**RE: Response to submissions
The Children's Hospital at Westmead Stage 2 Redevelopment
State Significant Development Application No. SSD-10434896**

This letter is to accompany the revised architectural drawings and design report for the above project application.

1 PROPOSED ELEVATION - NORTH
North

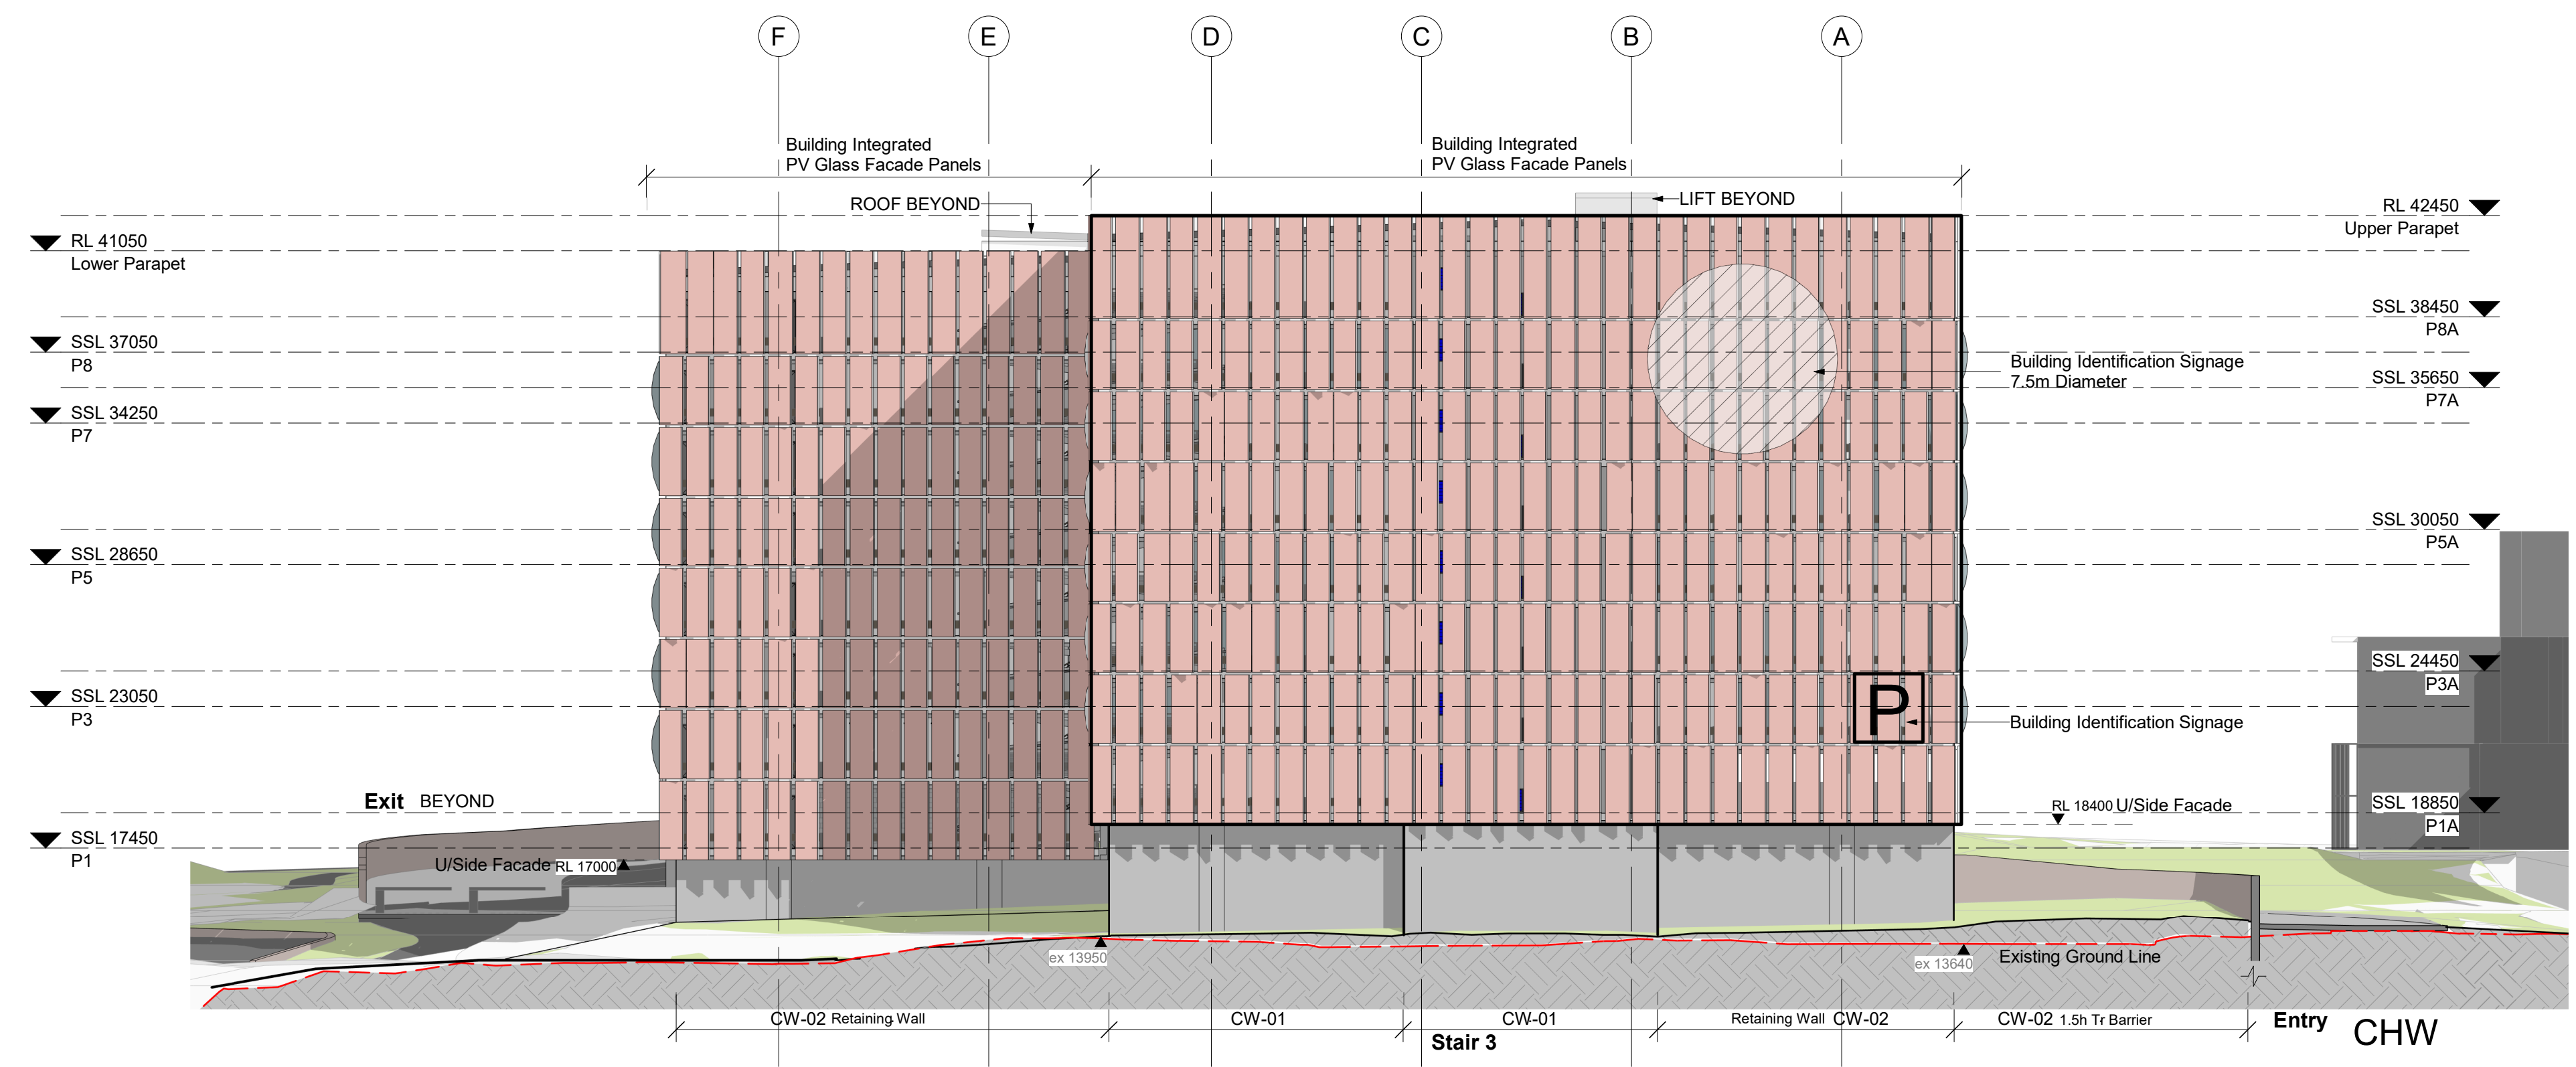
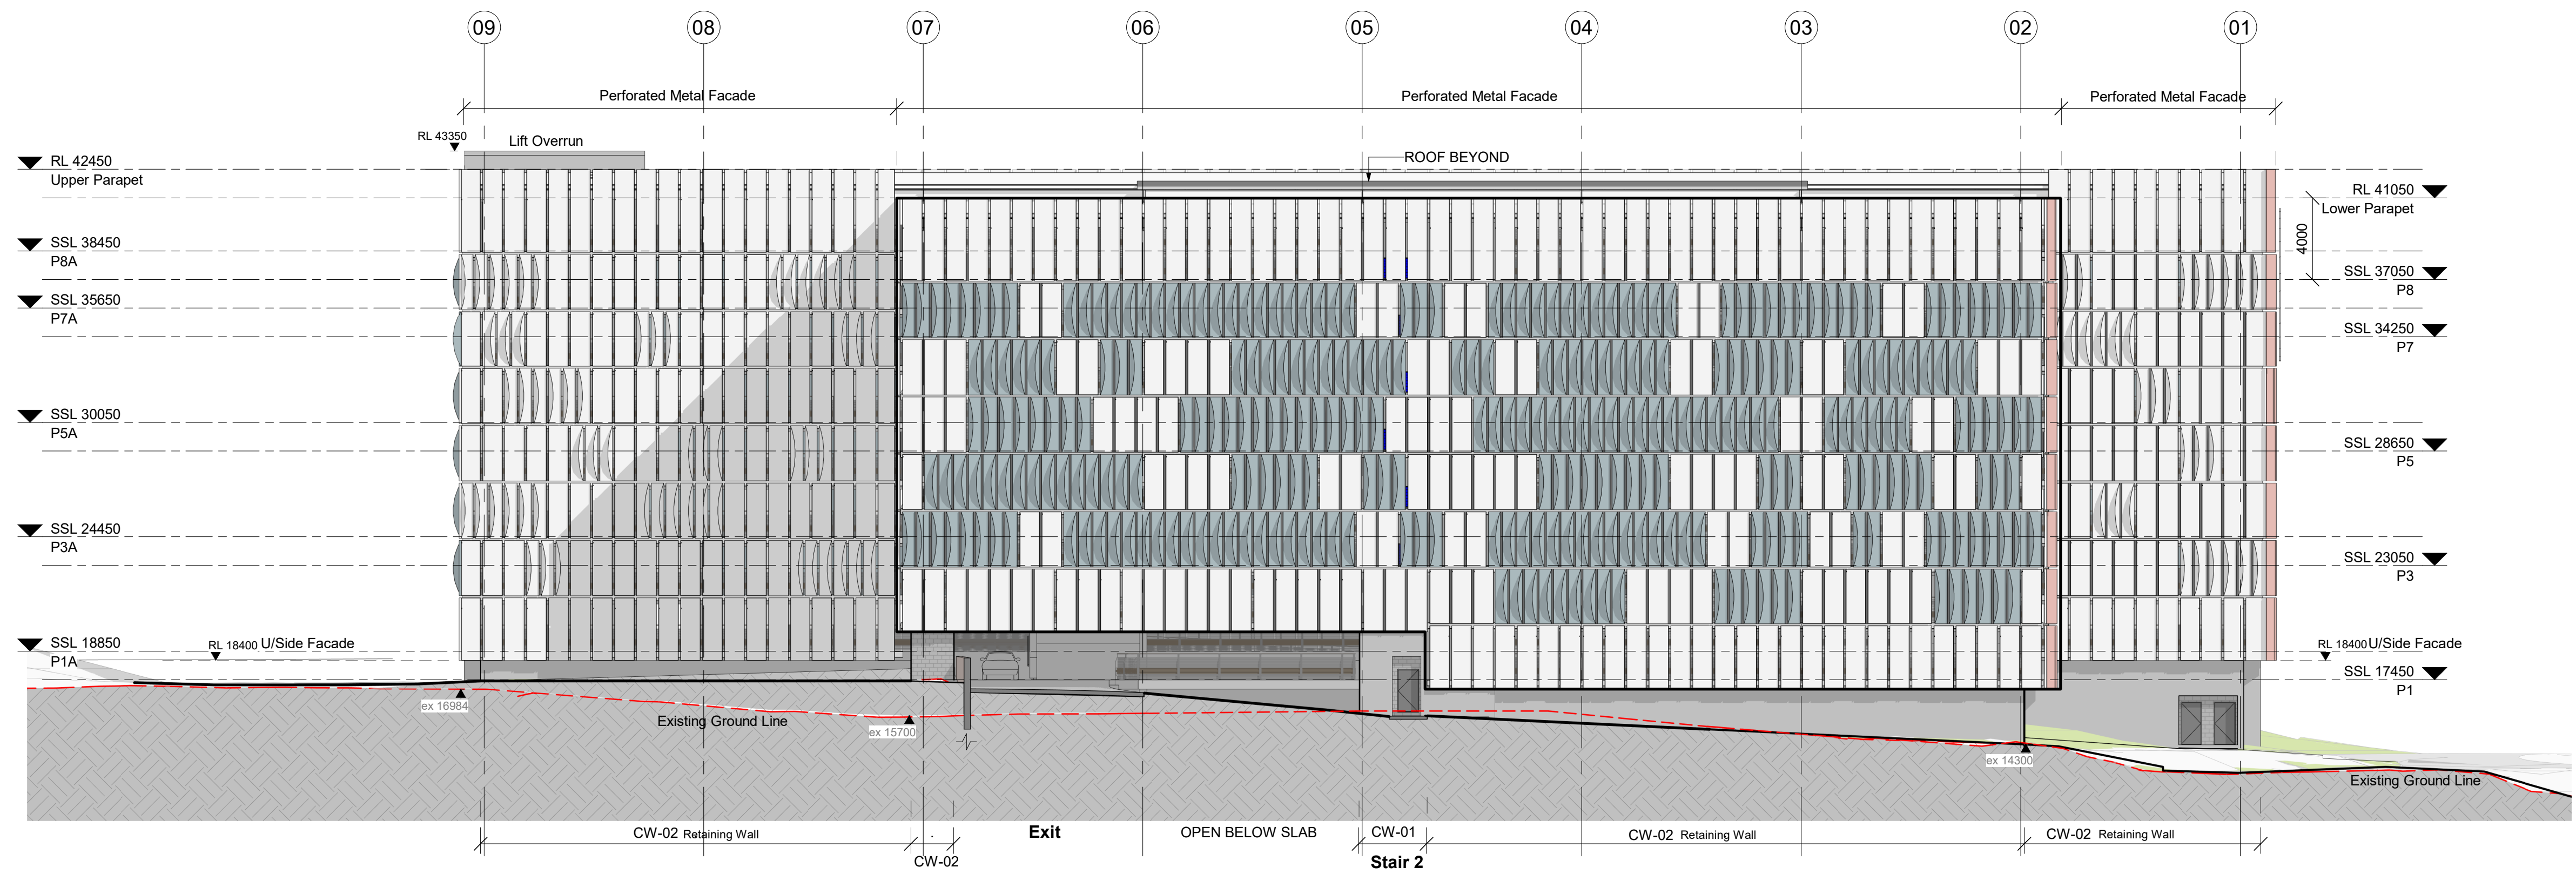
Comment from Agency / Organisation	BLP response
a) further detail of the proposed solar panel façade and/or roof canopy design in accordance with the ESD report.	The architectural design report has been revised to include detail of the PV glass façade.
